Subject: RE: EP/142/21/HH 38 Vermont Drive

Kathryn Welch
Planning Officer, Planning Department

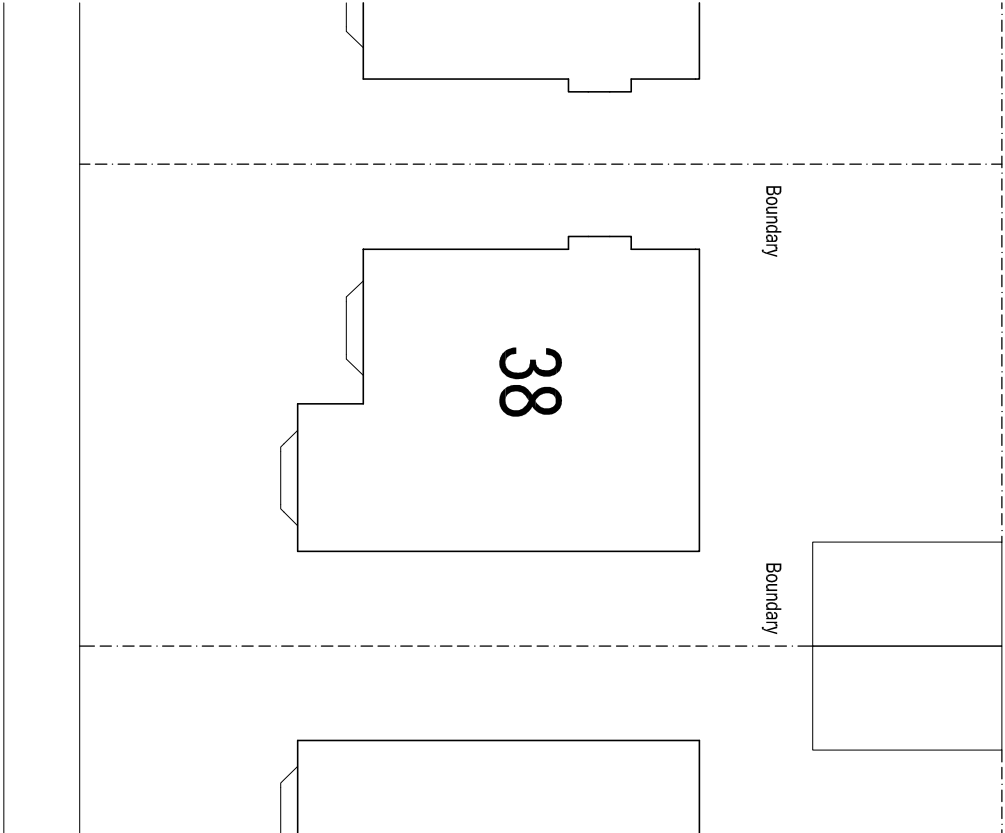
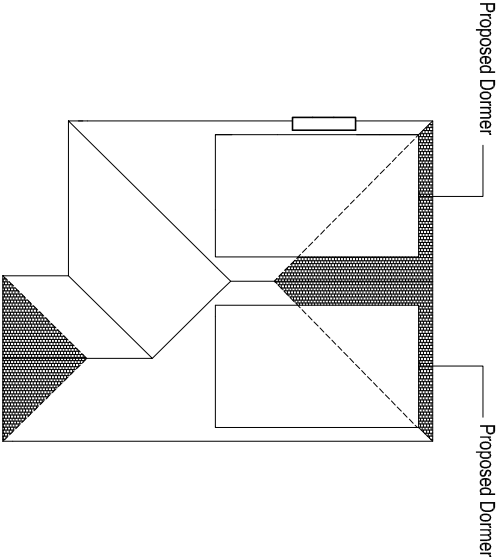
This section of Vermont Drive has a uniform feel and that the introduction of the two dormers to either side of the property would be out of character with the area and overbearing on the property, I do note that 2 doors down they have a single western facing dormer. I would therefore consider something similar more in keeping with other properties in the area.

I have no issue with the hip to gable alteration.

ARW Design	DRAWING TITLE: PROPOSED ELEVATIONS PROJECT: PROPOSED LOFT CONVERSION WITH HIP TO GABLE END & DORMERS TO SIDE ELEVATIONS		LOCATION: 38, VERMONT DRIVE, EAST PRESTON CLIENT: C. NORTH		SCALE: AS NOTED @ paper size A3 DATE: OCT 2021		DRAWING NO: 6037/2
					DRAWN: ARW		
					REVISION:

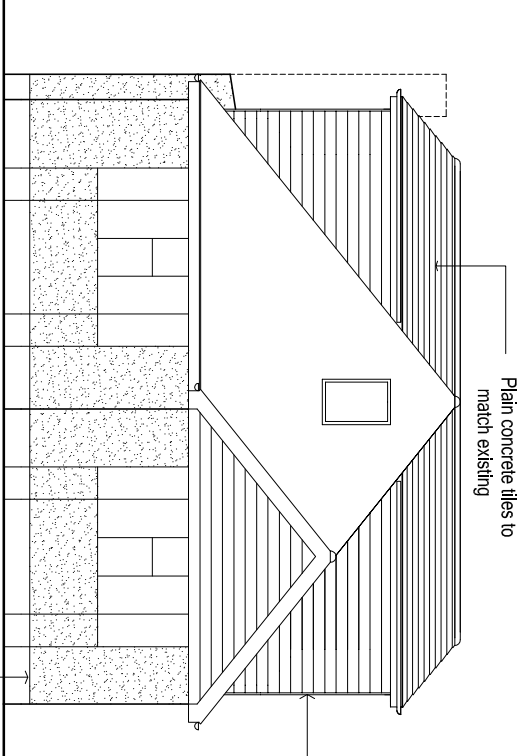
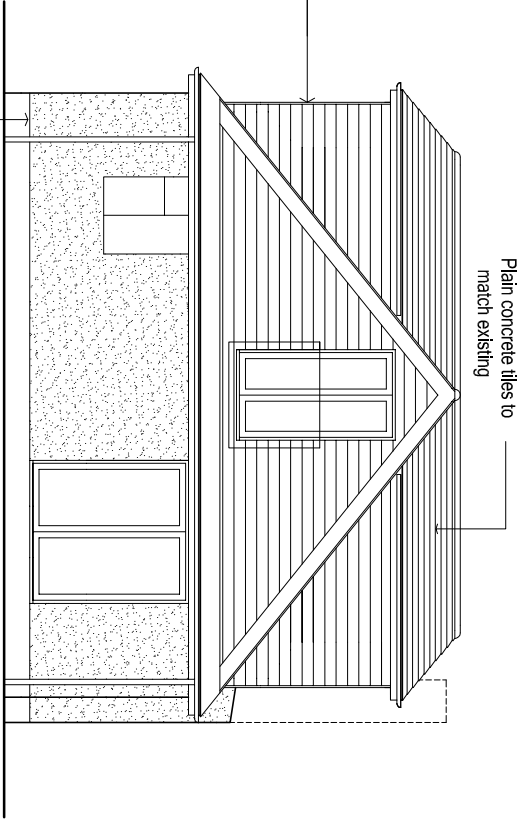
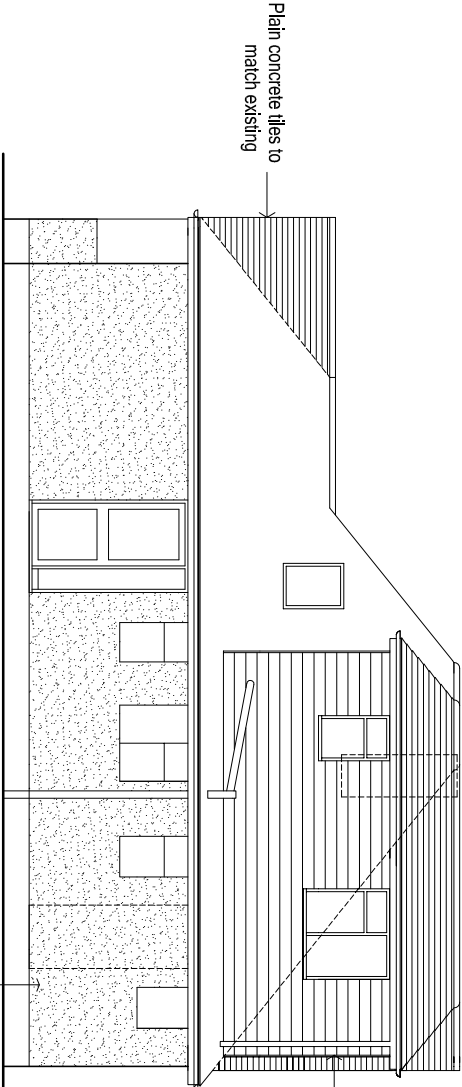
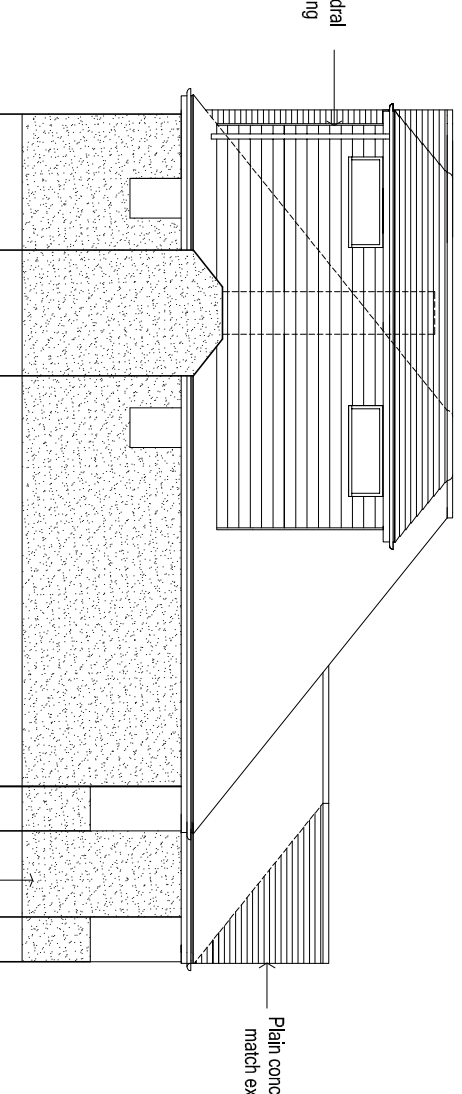
I note that you would take the northern elevation back to a hip to the front of the property, which I consider a positive improvement. However, I still consider the dormers to be overbearing and out

of character with the group 4 bungalows to this side of the road. Because of the applications at No 32 and 34 I'm not against a side dormer (especially as yours would have some form of pitched roof which I feel is a great improvement over those of No 32) but I feel their current extent is just too great. I have to consider their impact on all elevations, not just the frontage, and their impact to the street. From both an eastern and western approach, where now there are clear views to the properties behind (due to the valleys created between the hipped roofs), there will be a large expanse of dormers, I feel this needs to be rectified. I would also consider a traditional mix of materials more appropriate, especially if the impact of the project needs to be lessened.

Having regard to the overlooking window it would need to be obscure glazed and fixed shut below 1.7m for me to approve it, I can't allow the possibility of an opening window with views over the garden of No 36.

I also feel that the level of overlooking by the proposed westward facing dormer would give rise to an unacceptable loss of privacy to no 36, I would therefore be grateful if you could reconsider the fenestration to the proposed.

We are prepared to make some alterations including the removal of the small hip to gable on the front elevation to retain the existing appearance & match the other 4 bungalows in this respect.

Furthermore the side window to the west elevation is required for emergency egress purposes but could have obscured glass to limit overlooking.
